Yorkshire Green Energy Enablement (GREEN) Project

**Document 5.3.6A ES Chapter 6 Appendix 6A - EIA Scoping Opinion
Responses on Landscape and Visual Assessment**

Planning Inspectorate Reference: EN020024

5.4.6, ES CHAPTER 6  
 LANDSCAPE AND VISUAL FIGURES  
 FIGURE 6.1  
 LANDSCAPE AND VISUAL IMPACT  
 ASSESSMENT STUDY AREAS

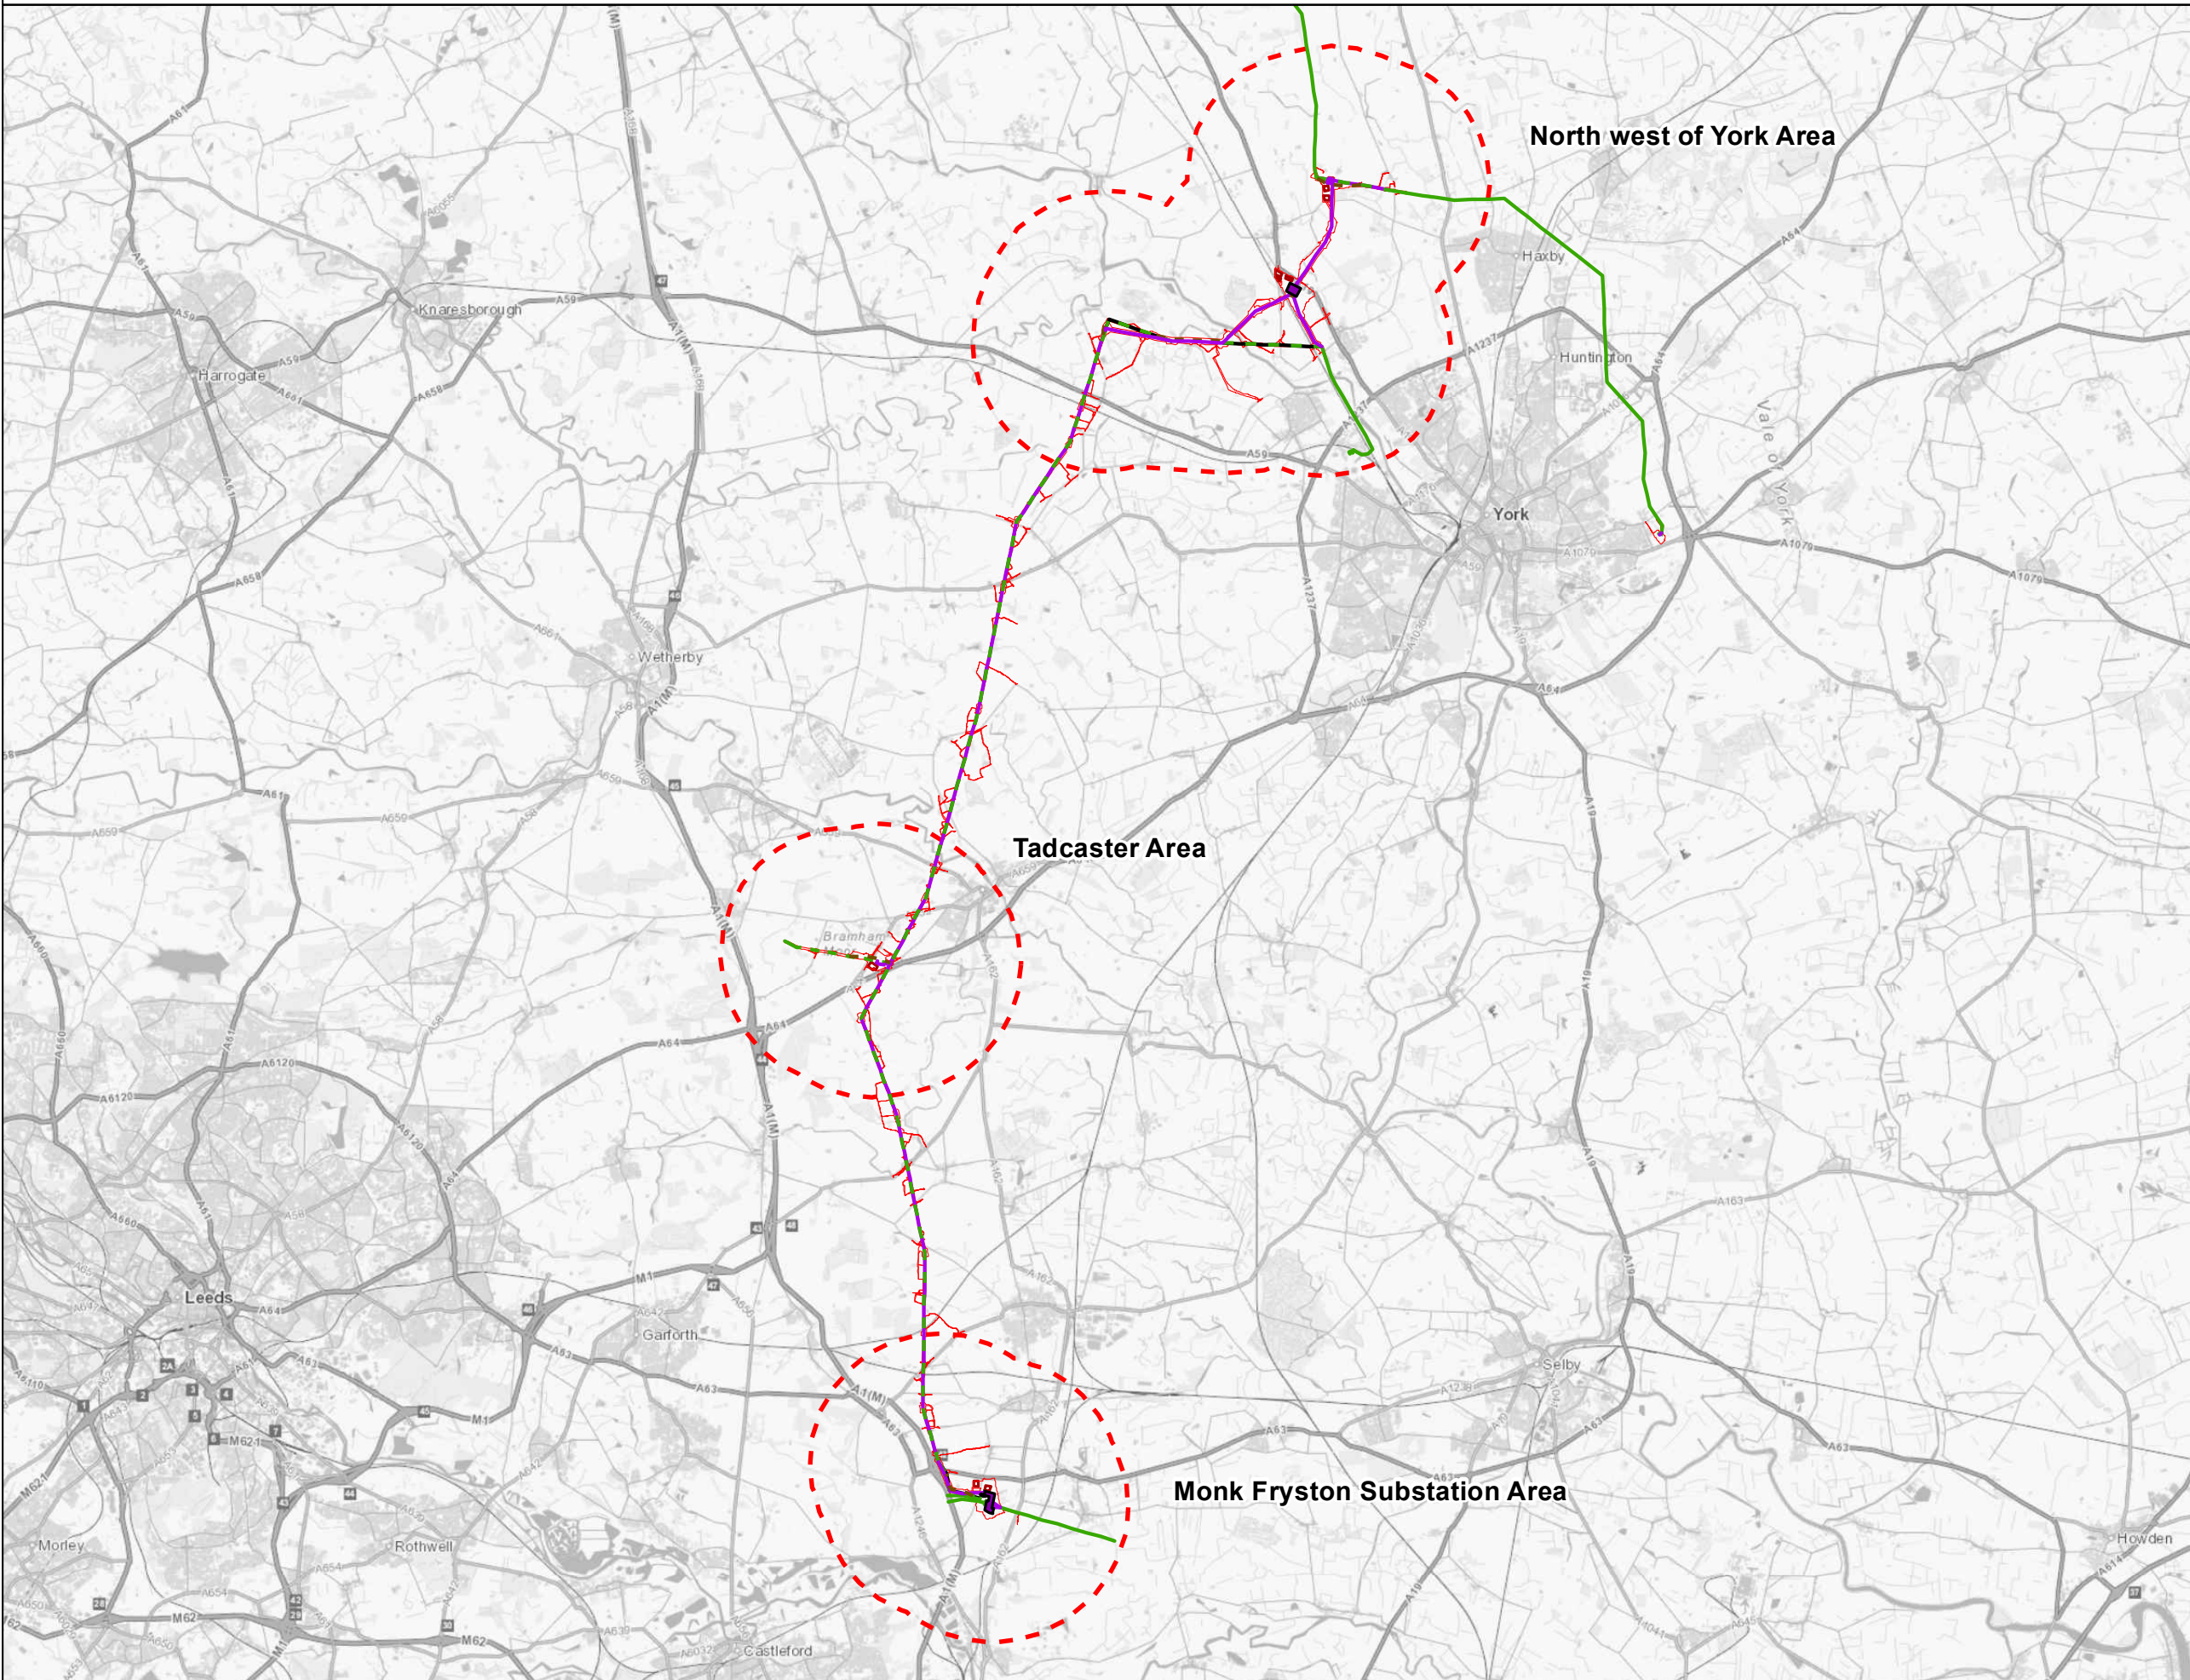
NYCC 18		North Yorkshire County Council: Maximum LVIA Study Area of 3km from the Project supported.	The Study Areas for the LVIA are shown in Figure 6.1, Volume 5, Document 5.4.6 and described in Section 6.4 of Chapter 6: Landscape and Visual Amenity, Volume 5, Document 5.2.6.
NYCC 19		North Yorkshire County Council: The principle of establishing a ZTV using a DTM is acceptable but this should be verified through fieldwork to establish an accurate visual envelope.	The plotting of an accurate visual envelope on a plan is not a requirement of best practice guidance and it has subsequently been agreed with North Yorkshire County Council not to include such plans as reported
